From: Mundy, Ben - Oxfordshire County Council <Ben.Mundy@Oxfordshire.gov.uk>
Sent: 01 February 2023 15:43
To: DC Support; Rebekah Morgan
Cc: Transport CDC Minor; Cllr Ian Corkin
Subject: 22/03756/F Wendlebury Park Farm, Wendlebury Road, Chesterton, Bicester, OX25 2PE

Planning Application: 22/03756/F

Location: Wendlebury Park Farm, Wendlebury Road, Chesterton, Bicester, OX25 2PE

Description: Additional building within existing yard area for associated B1 and B8 use.

DRAWING NUMBER:
5442 / 20C

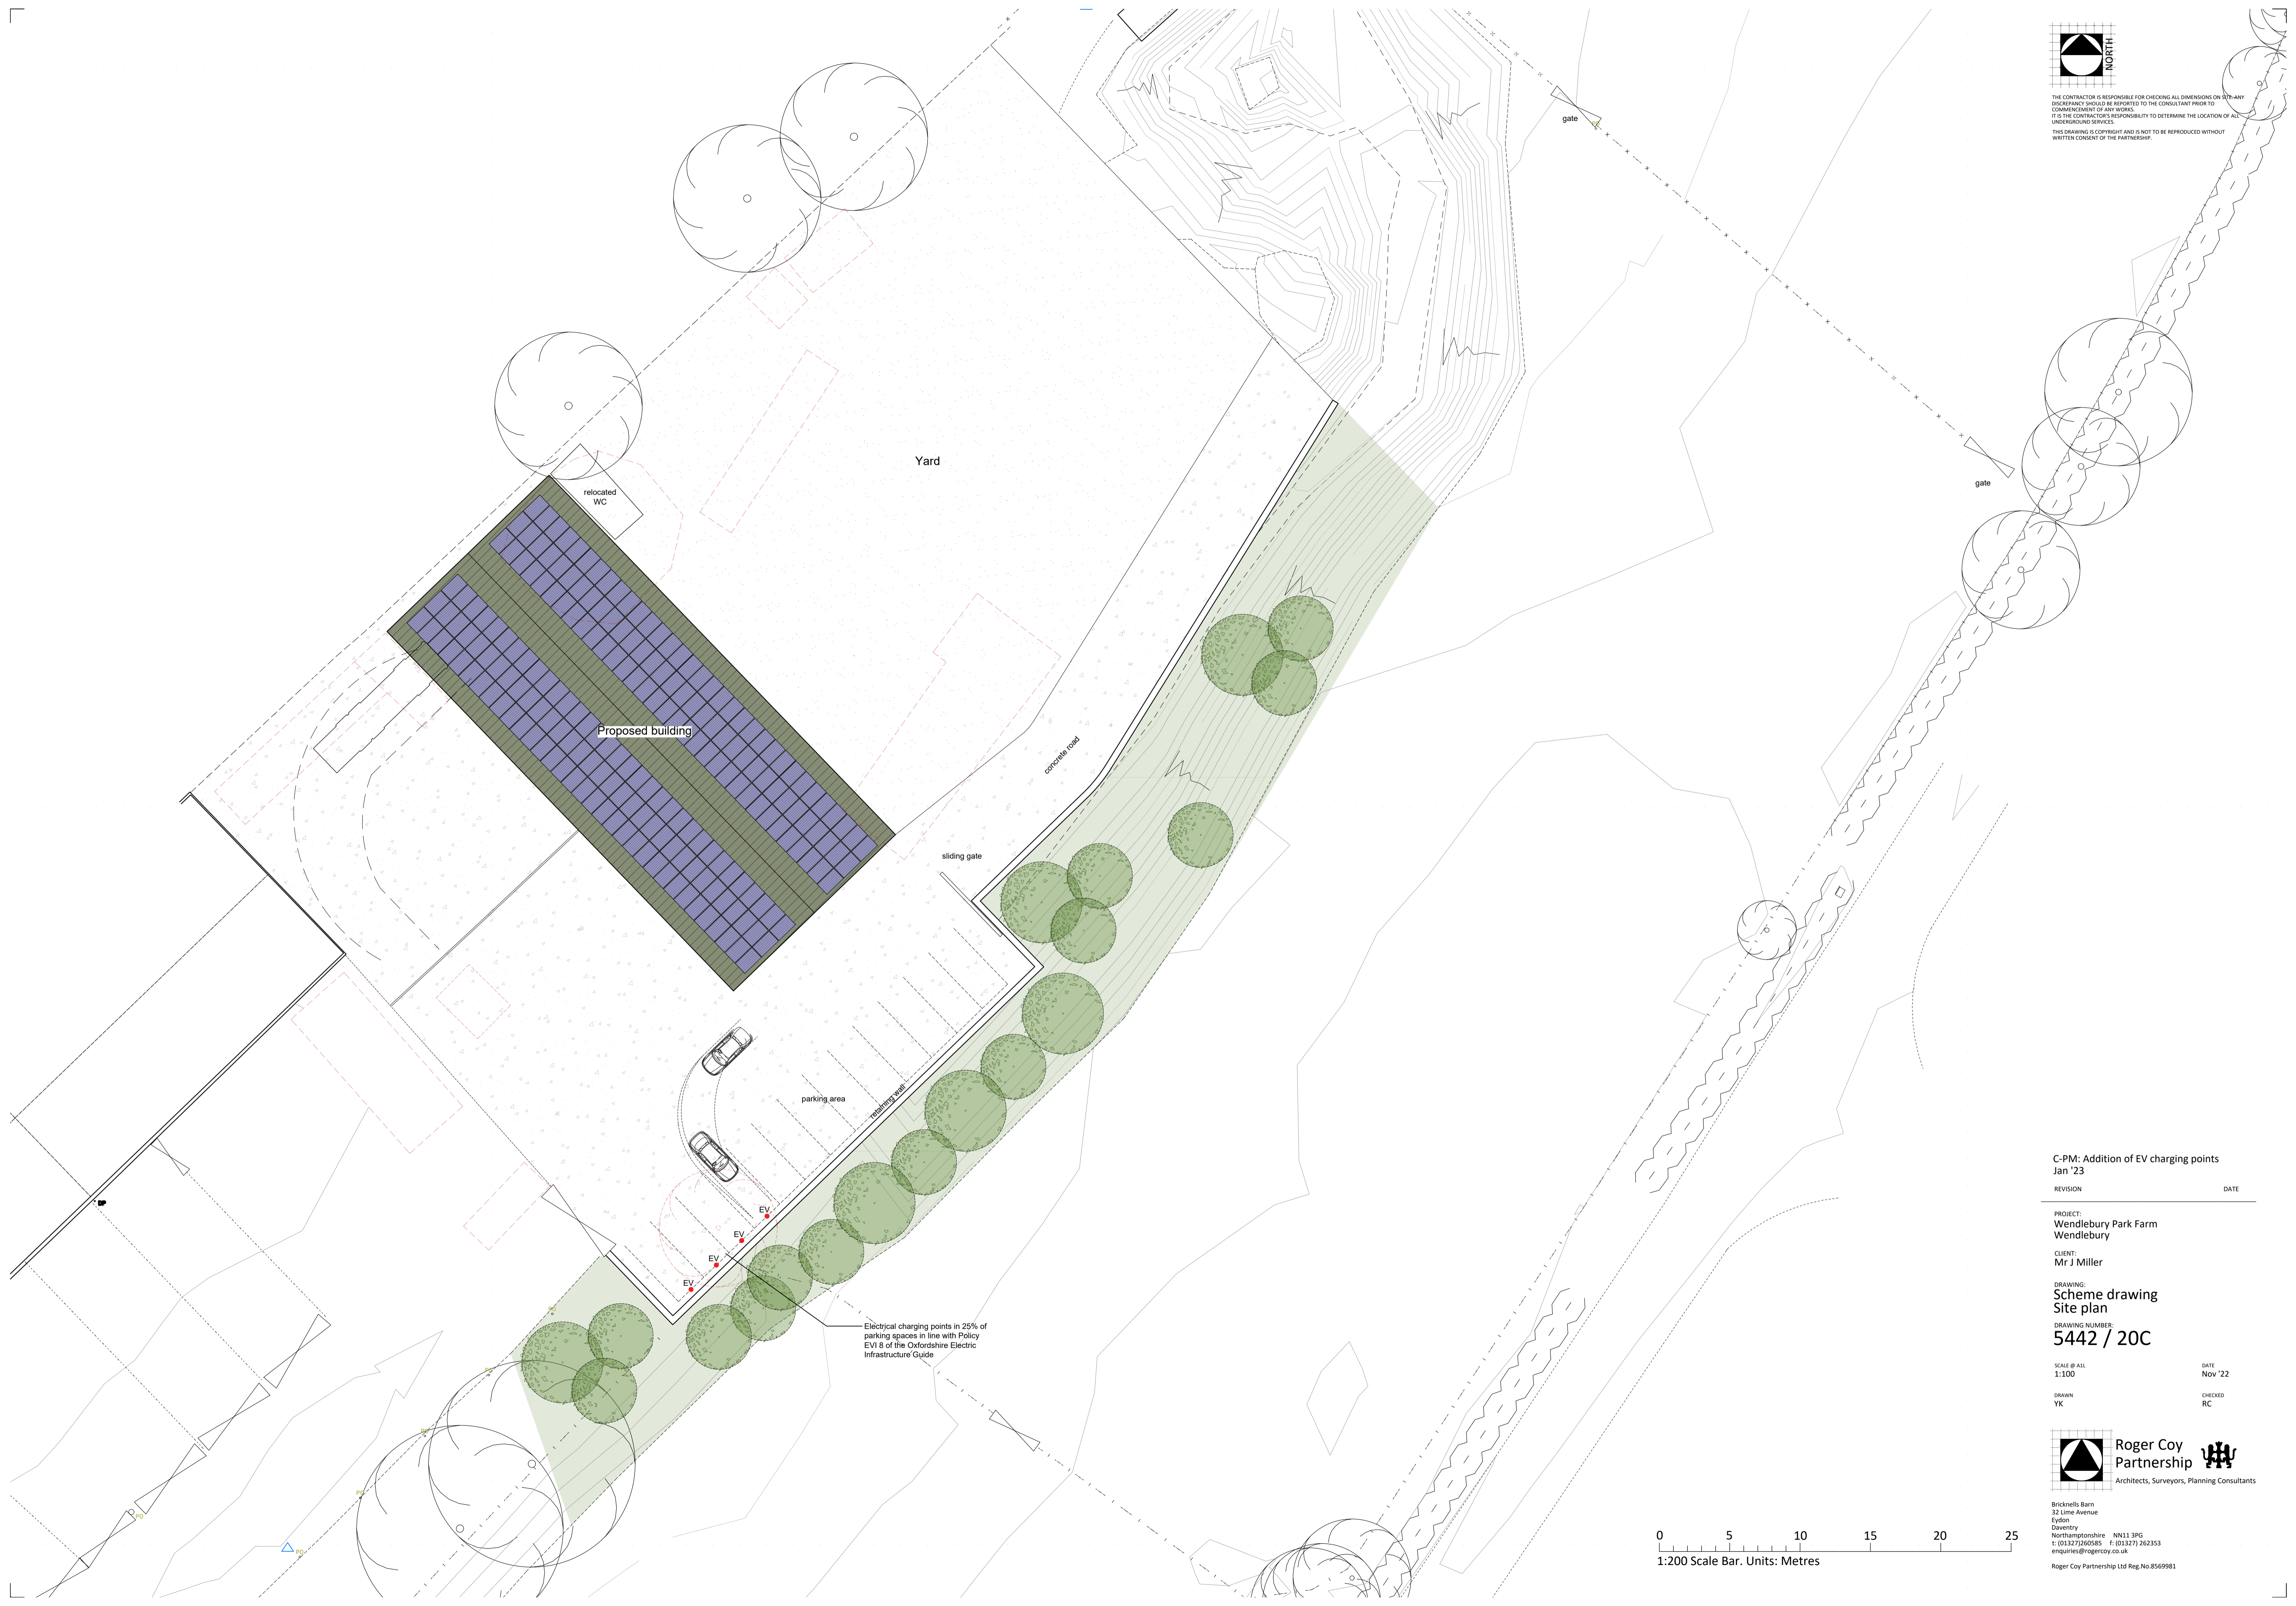
The developer has submitted revised plans of the site to include E/V charging points that I previously conditioned, I raised no other concerns regarding this application.
